**City of Portland, Maine - Building or Use Permit Application**  
 389 Congress Street, 04101 Tel: (207) 874-8703, Fax: (207) 874-8716

<b>Permit No:</b> 03-0375	<b>Issue Date:</b>	<b>CBL:</b> 012 B005001
------------------------------	--------------------	----------------------------

<b>Past Use:</b> Condo Unit	<b>Proposed Use:</b> Condo Unit / Add exterior door, replace stair with spiral stairs and construct balcony.	<b>Permit Fee:</b> \$86.00	<b>Cost of Work:</b> \$9,000.00	<b>CEO District:</b> 1
<b>Proposed Project Description:</b> Add exterior door, replace stair with spiral stair and construct balcony.		<b>FIRE DEPT:</b> <input type="checkbox"/> Approved <input type="checkbox"/> Denied	<b>INSPECTION:</b> Use Group: Type	
		Signature:	Signature:	
<b>PEDESTRIAN ACTIVITIES DISTRICT (P.A.D.)</b> <input type="checkbox"/> <input type="checkbox"/> Approved w/Condition <input type="checkbox"/>

PROPOSED

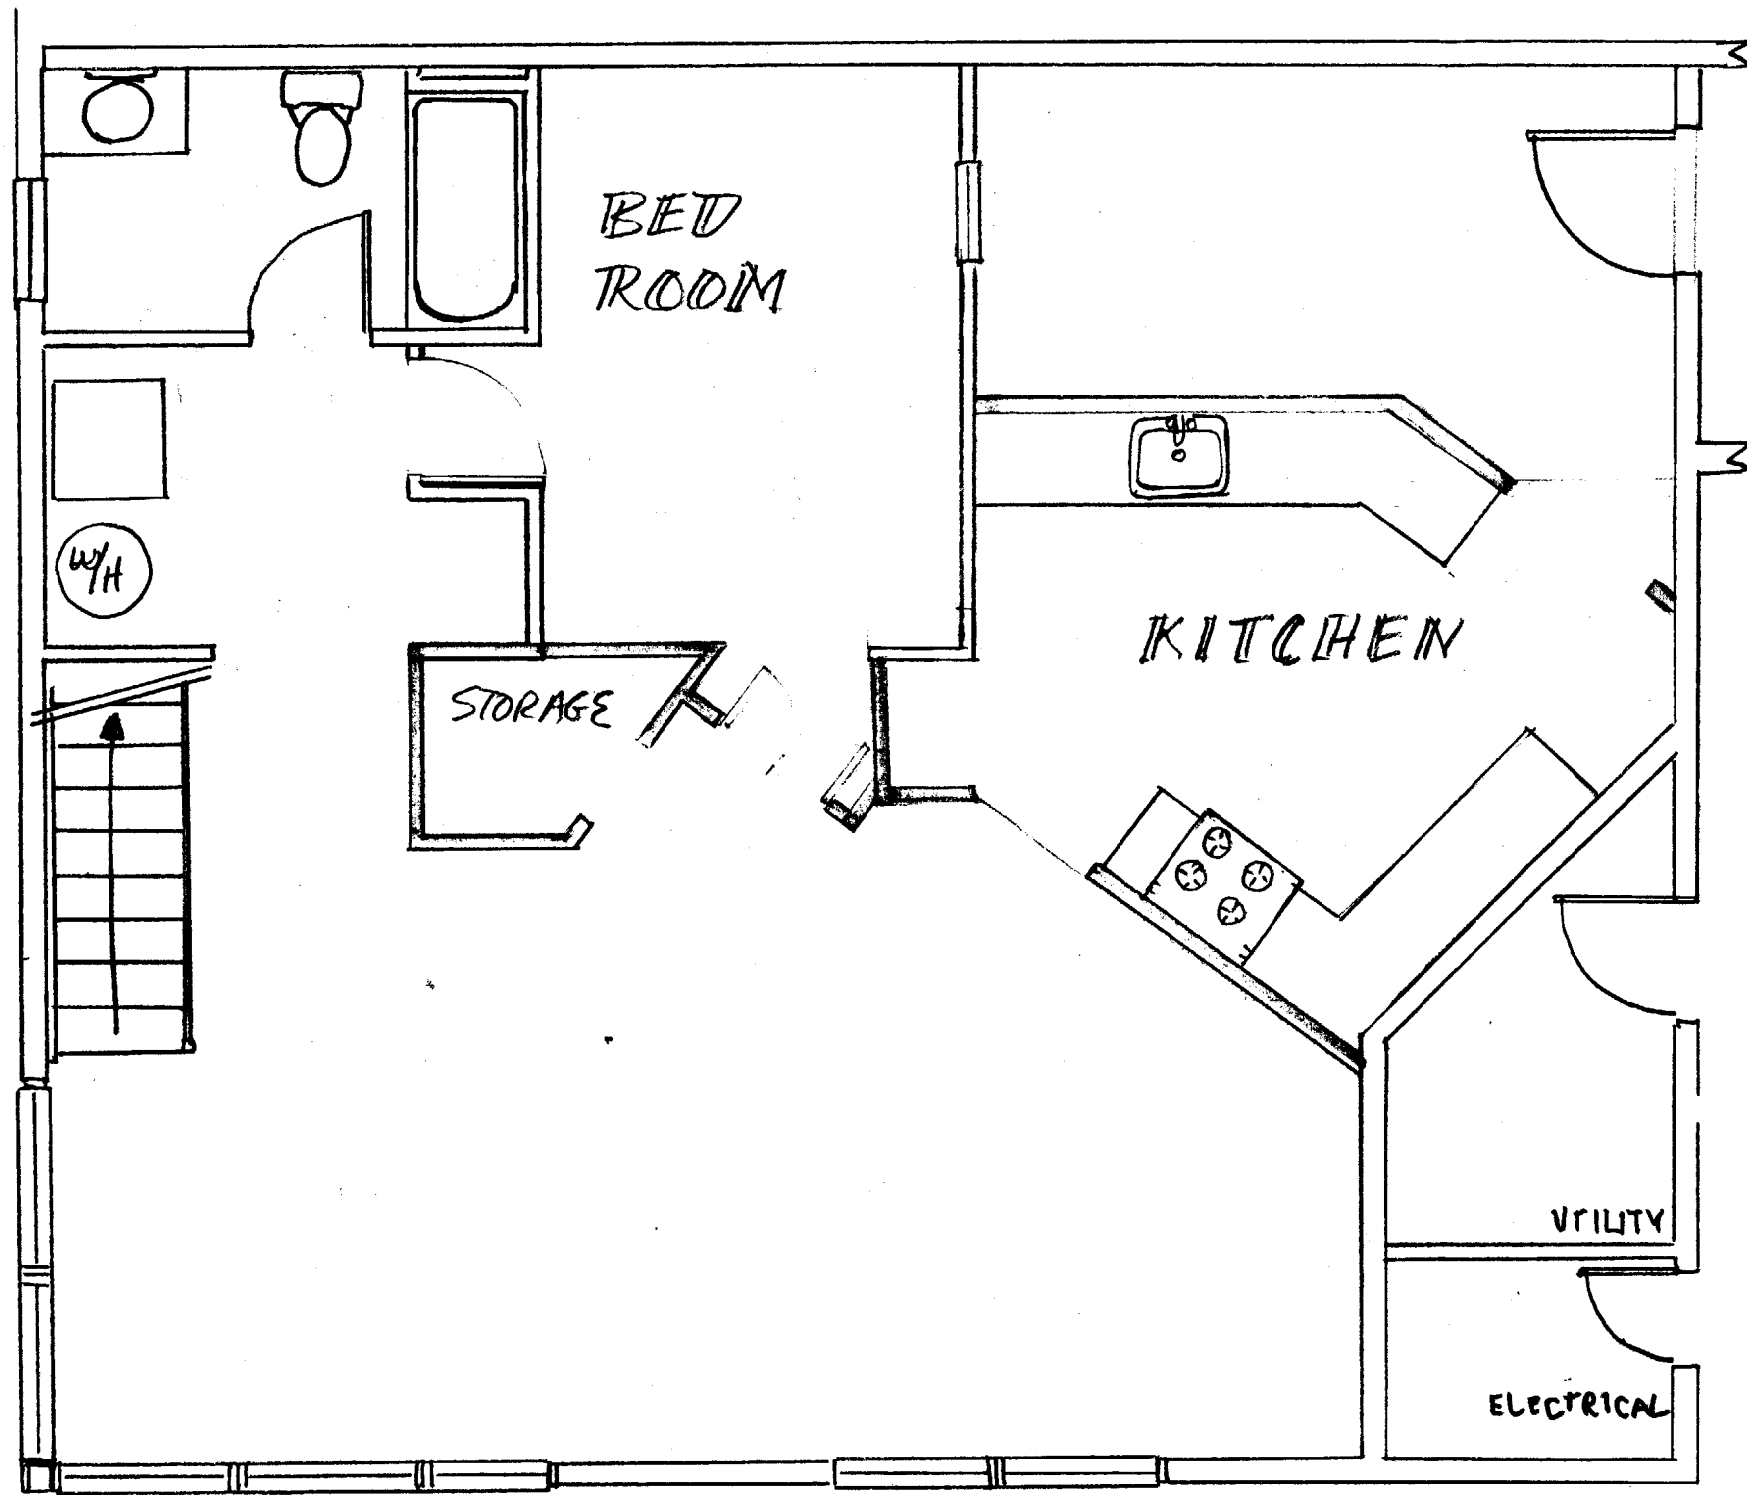
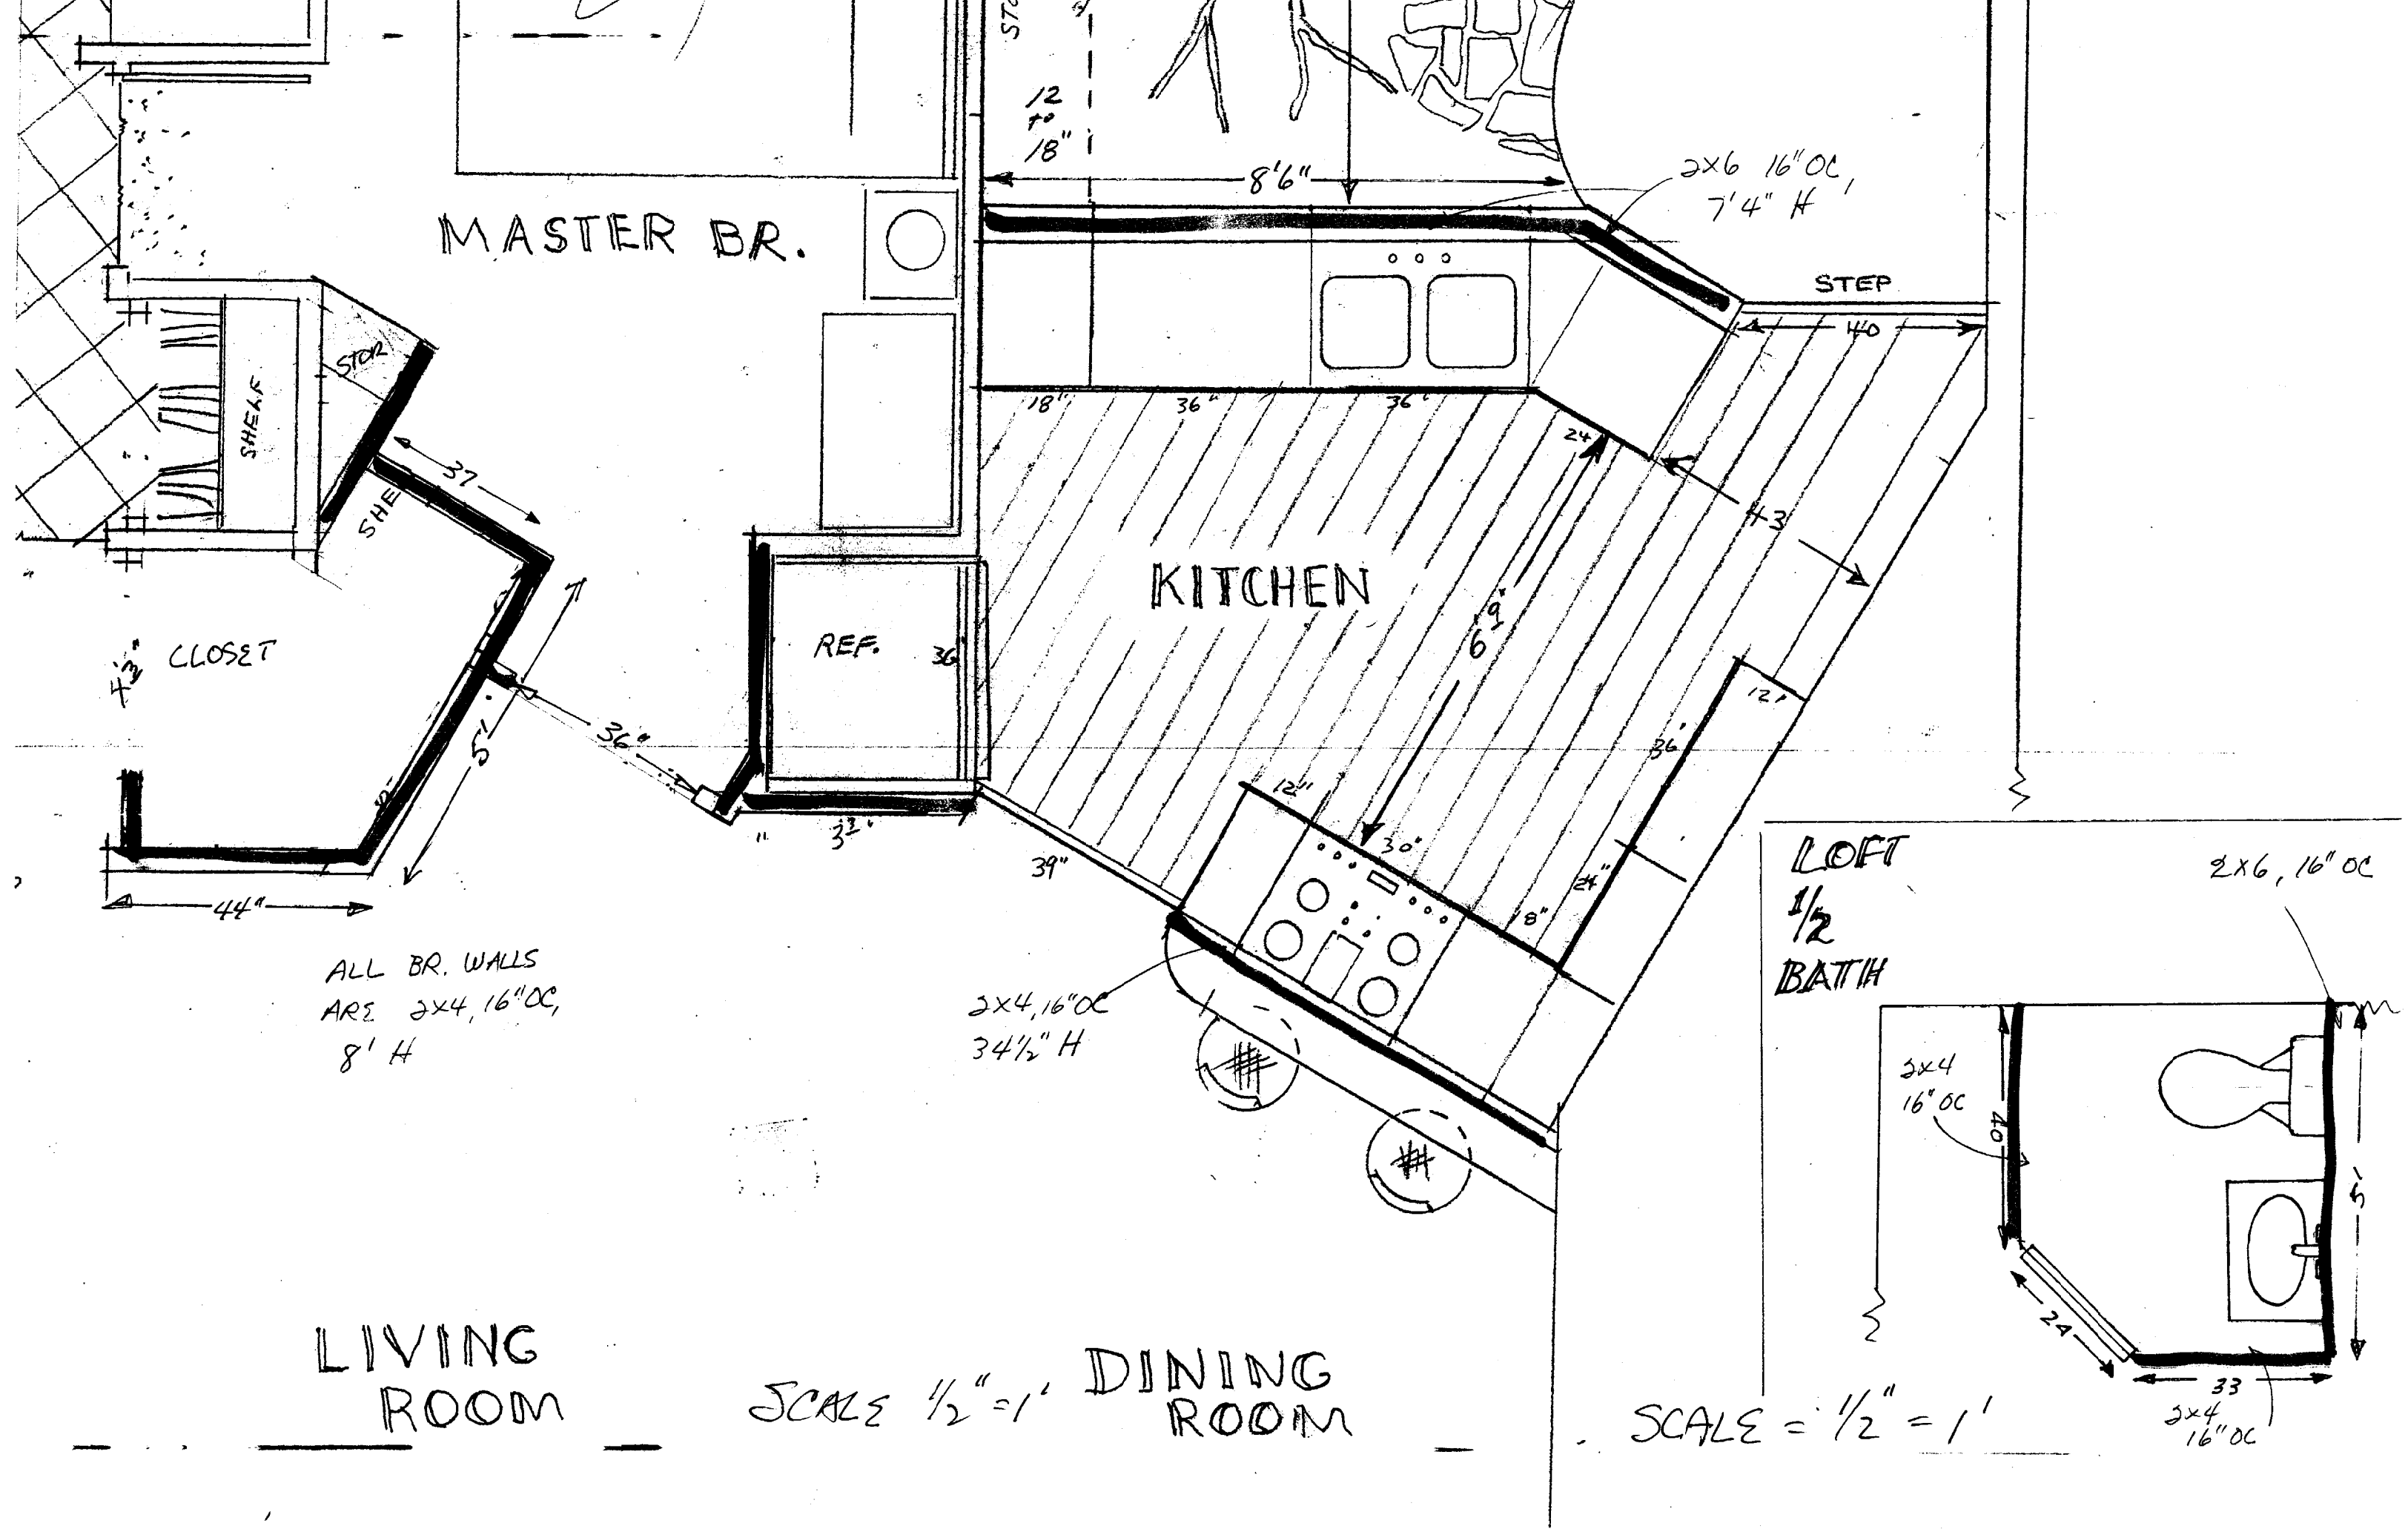
**Comments:**  
05/02/2003-mjn: need structurals on landing and farming detail for door.
